Recommendation: Approve

Applicant: Mr & Mrs O'Hare

Proposal: Single storey rear extension and increase in size of the garage including first floor side extension

Drawing Title:  
Proposed Plans  
Drawing Number:  
168-10  
Scale:  
1:100 @ A2  
Date:  
February 2023

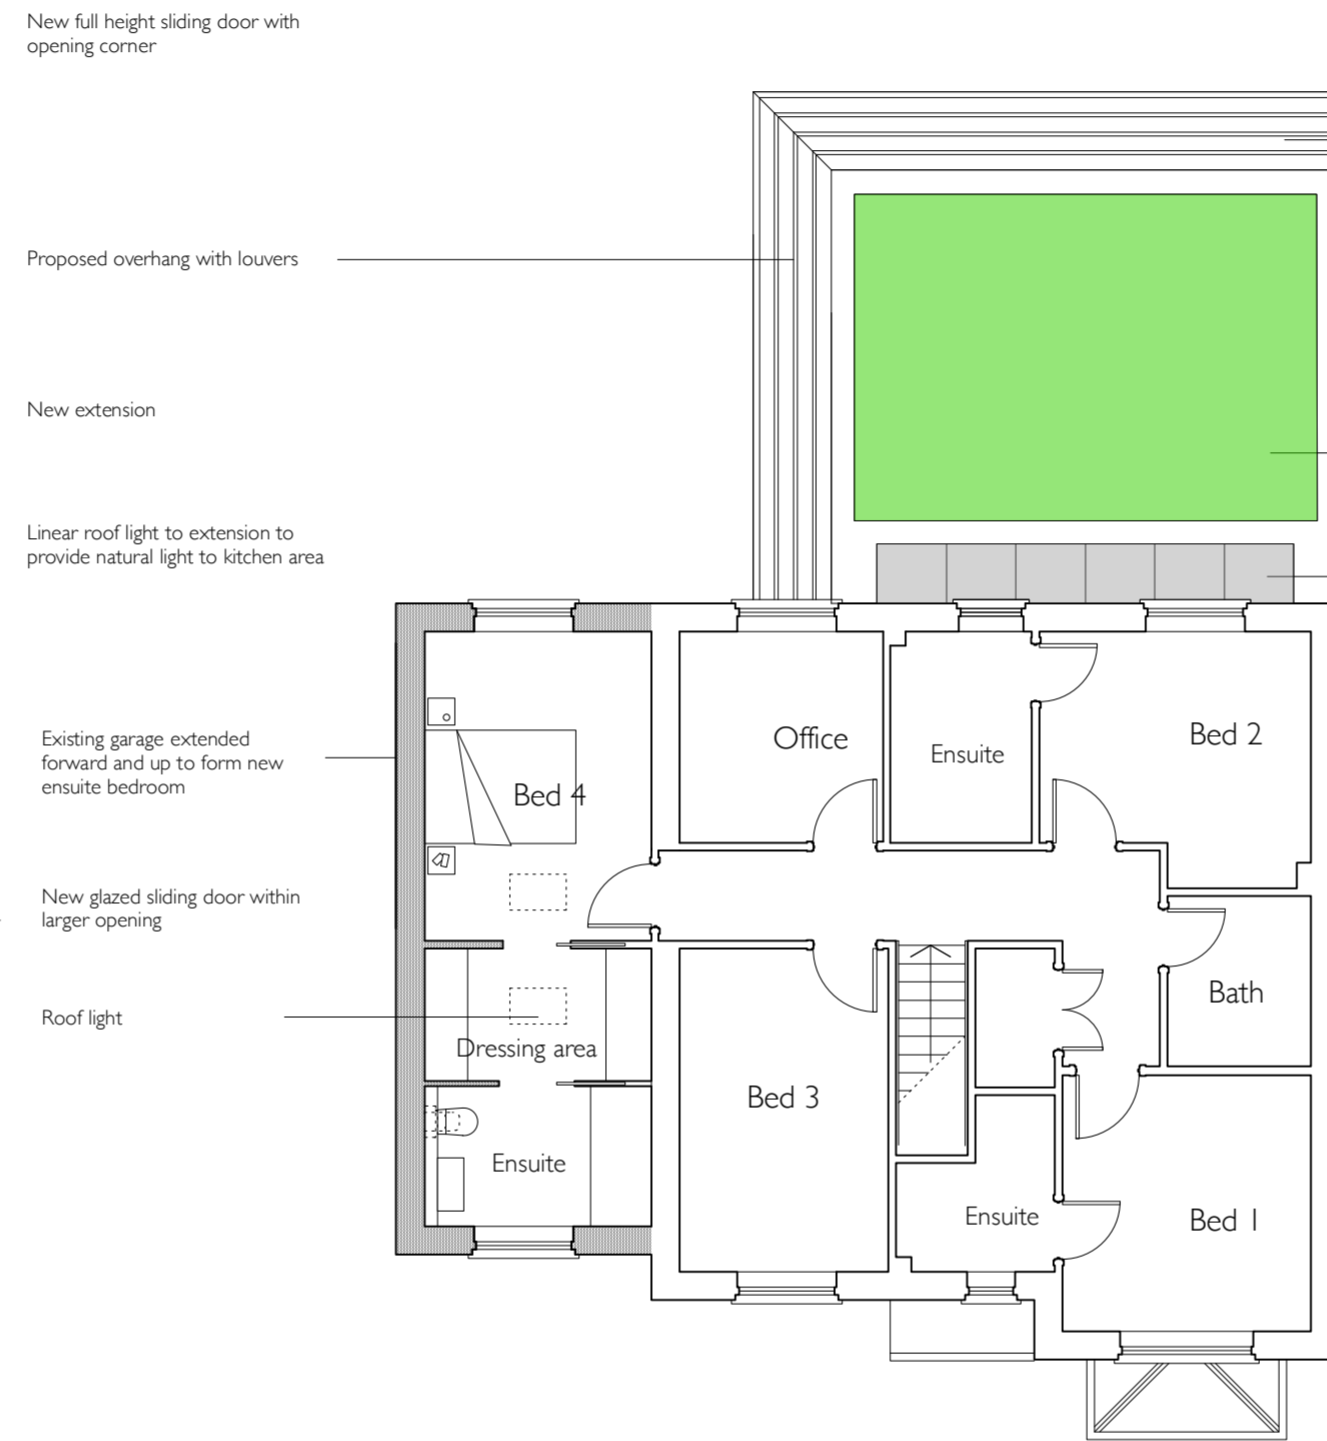
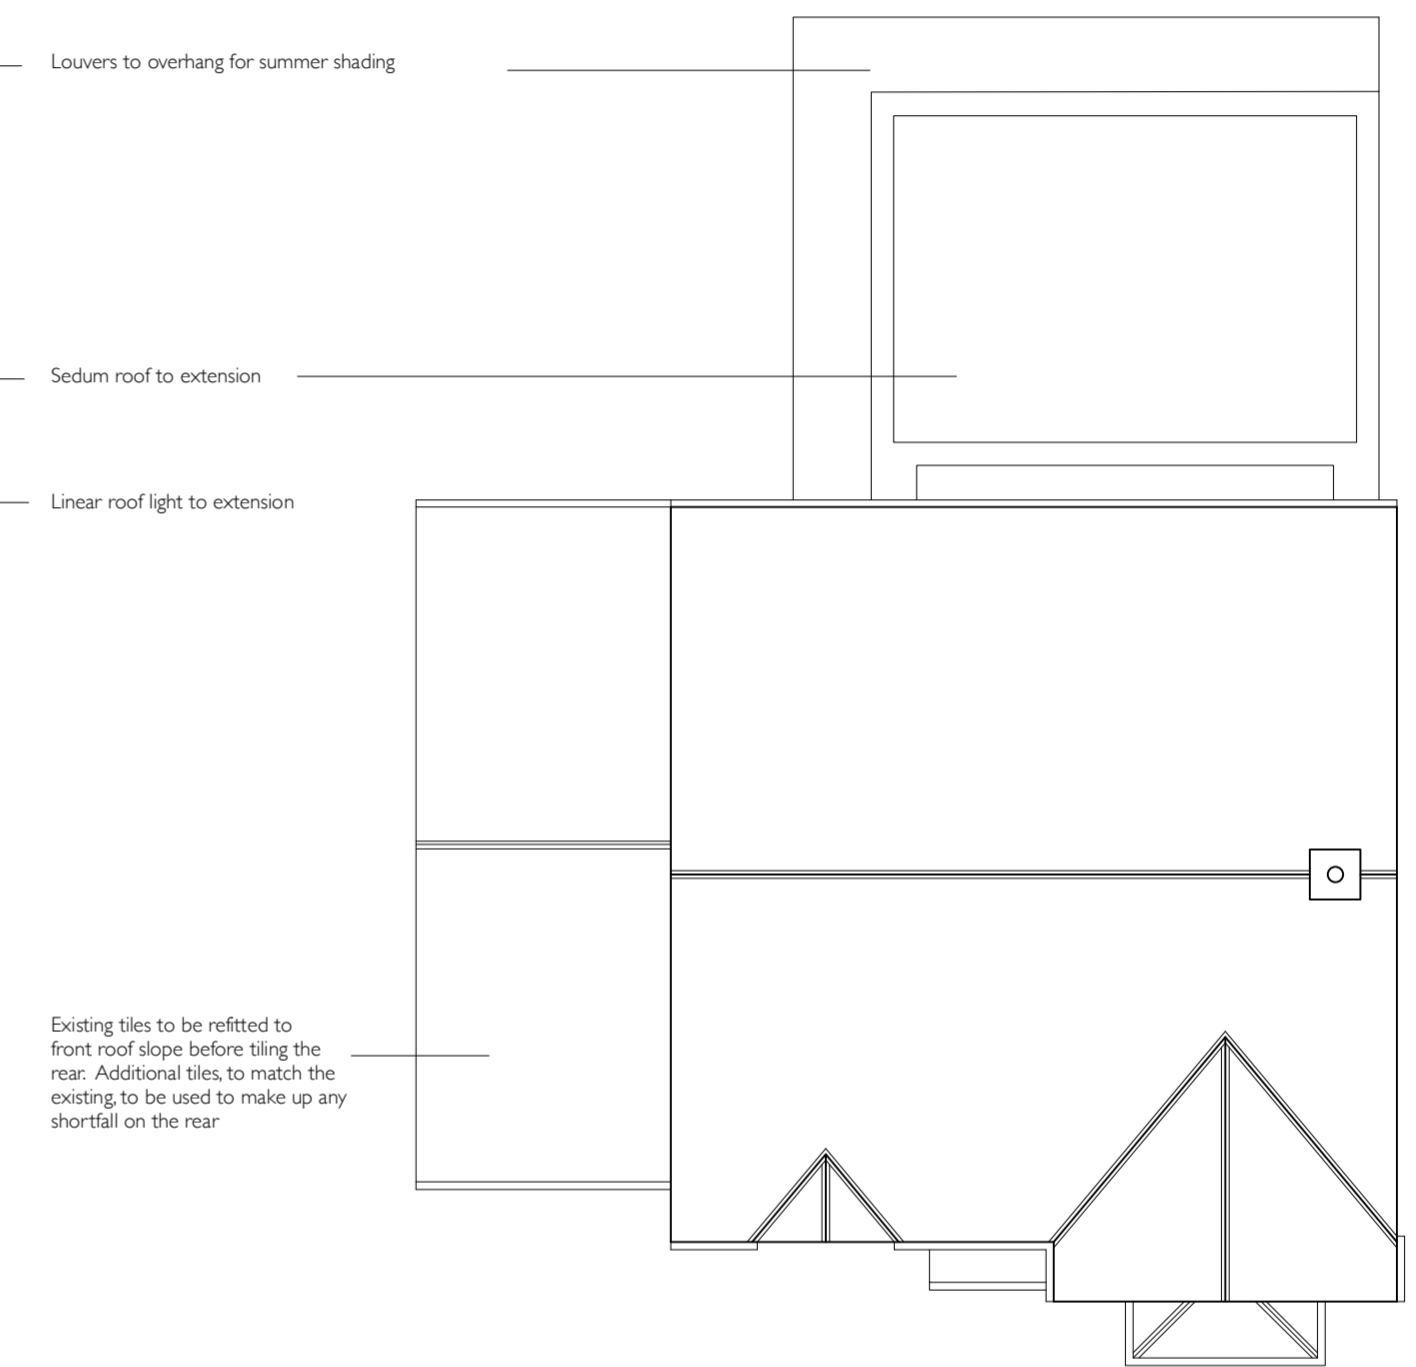
The proposed rear extension depth is considered modest and proportionate to the existing dwelling. This ensures the extension is subservient to the dwelling and the original house remains the dominant element of the property. Although flat roofed extensions are considered to normally represent poor design, the location to the rear of the property means that the extension would be largely obscured from the public realm and would have no impact on the character of the area.

The rear extension is set off the west facing elevation. The development also, is set off from the shared boundary with No. 3 and No. 5 and the relatively modest depth of the extension is not considered significant to prevent harm to either neighbour through overshadowing, overdominance and visual intrusion.

Drawing Title:  
Proposed Elevations

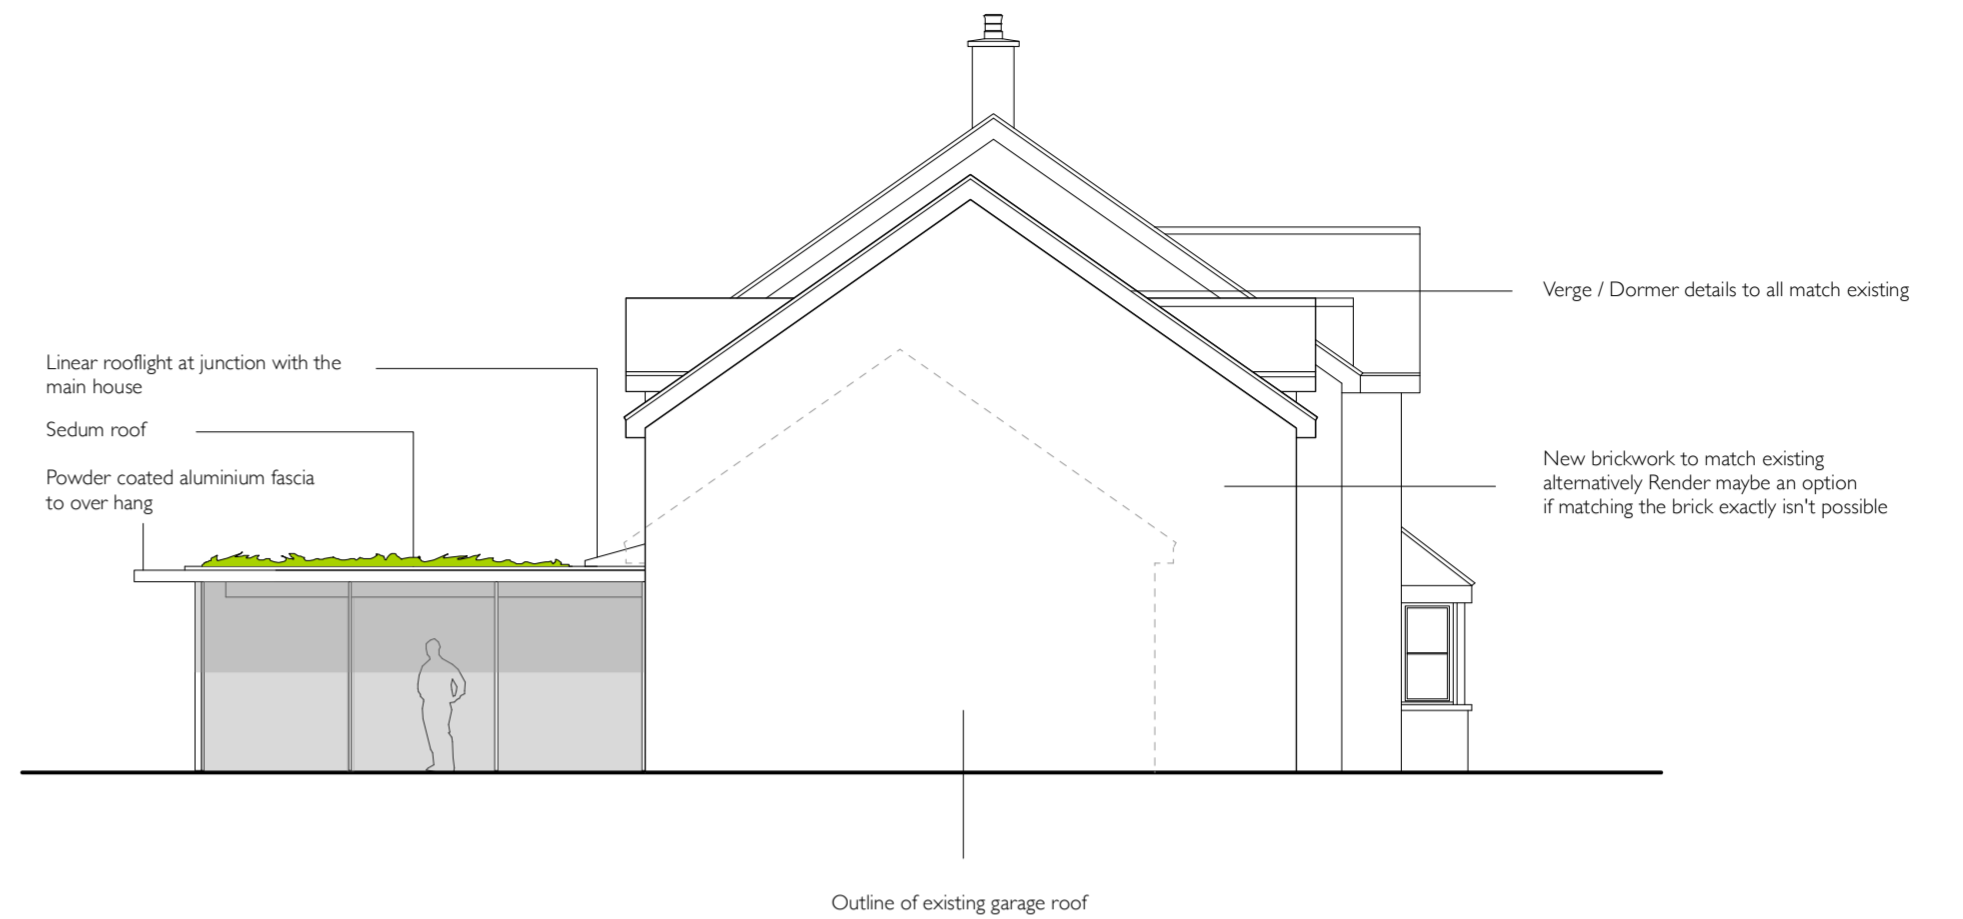
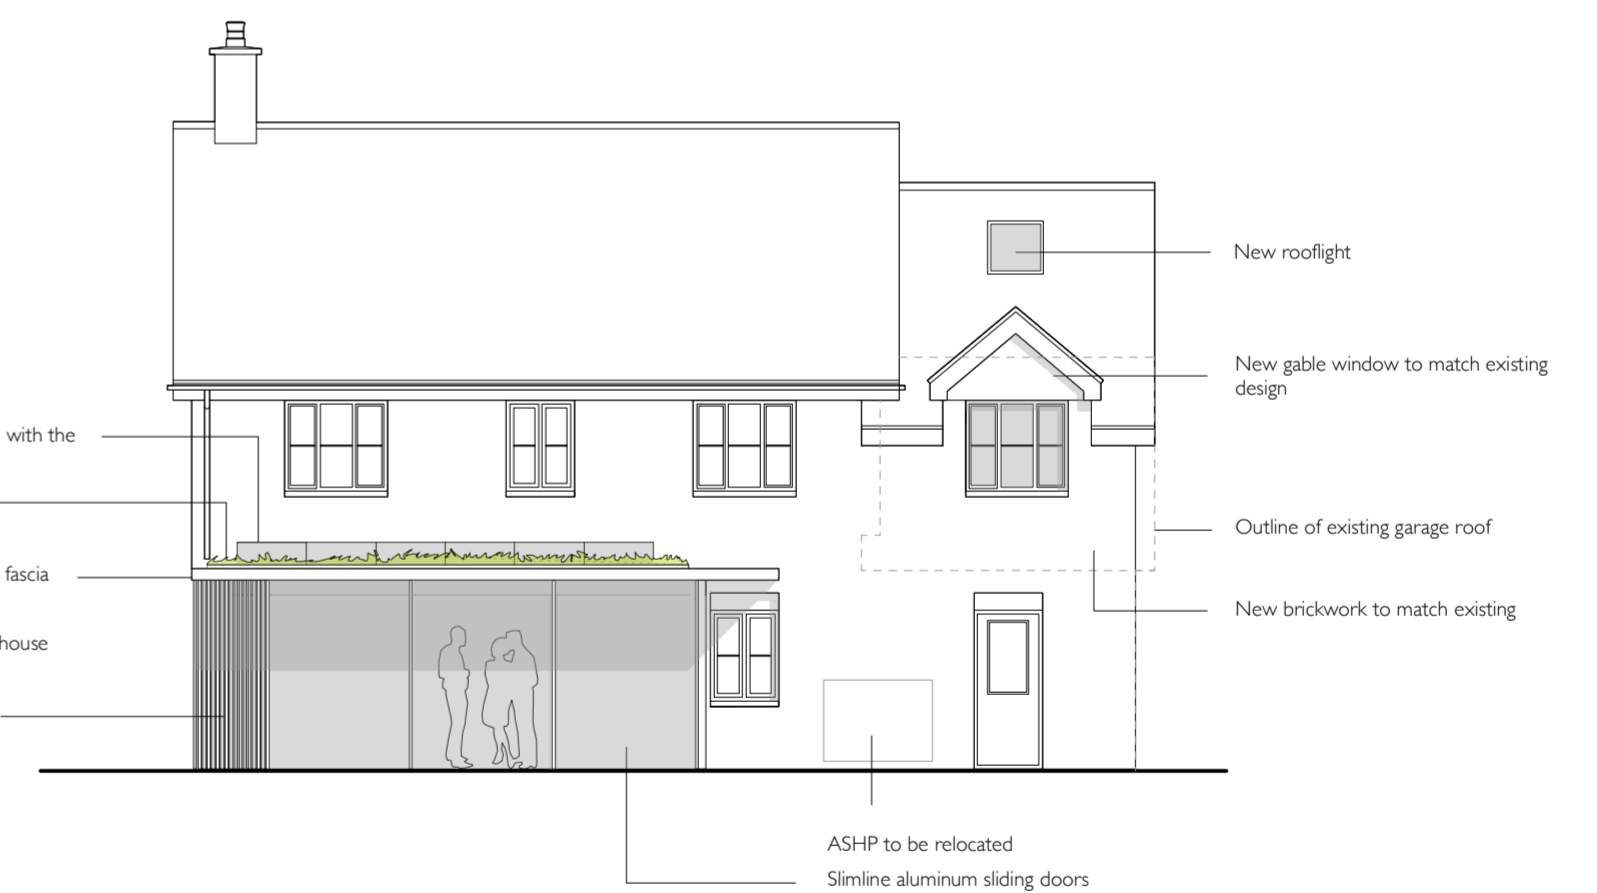
Raising the height of the garage as proposed will create an effectively continuous high roofline across this and the neighbouring property (600m is negligible subordination); this will block access for swifts to the swift brick on the end wall of No. 3 as the birds need room to swoop upward to nest sites. Swift bricks should be included in the front and rear elevations of the proposed garage extension to provide alternative sites for the birds. The village has a sizeable summer population of swifts which will benefit from increase nesting options. The birds use the front and rear elevations of the existing terraced properties for nest sites, so the aspects appear acceptable to them.

The first floor extension would be to the side of the application dwelling and would be readily visible from the public domain and would have a significant impact on the character and appearance of the street scene.

The plans also the proposal would be set down from the existing ridge line and set back from the principal elevation this shows subservience between the original ridge line and the proposed extension and would adhere to the guidance within the Cherwell District Council Home Extensions and Alterations Design Guide (2007).

Whilst it would still be a relatively close relationship between 3 and 4 Field View Lane, it is considered, on balance, not to be so harmful as to warrant a refusal on grounds of visual amenity.

The neighbour questions the potential loss/inaccessibility of swift bricks which they state have been inserted into the original build. Having checked the discharge of condition in respect of ecology for the original development, there was no requirement for swift bricks (although the Council's Ecologist would have preferred
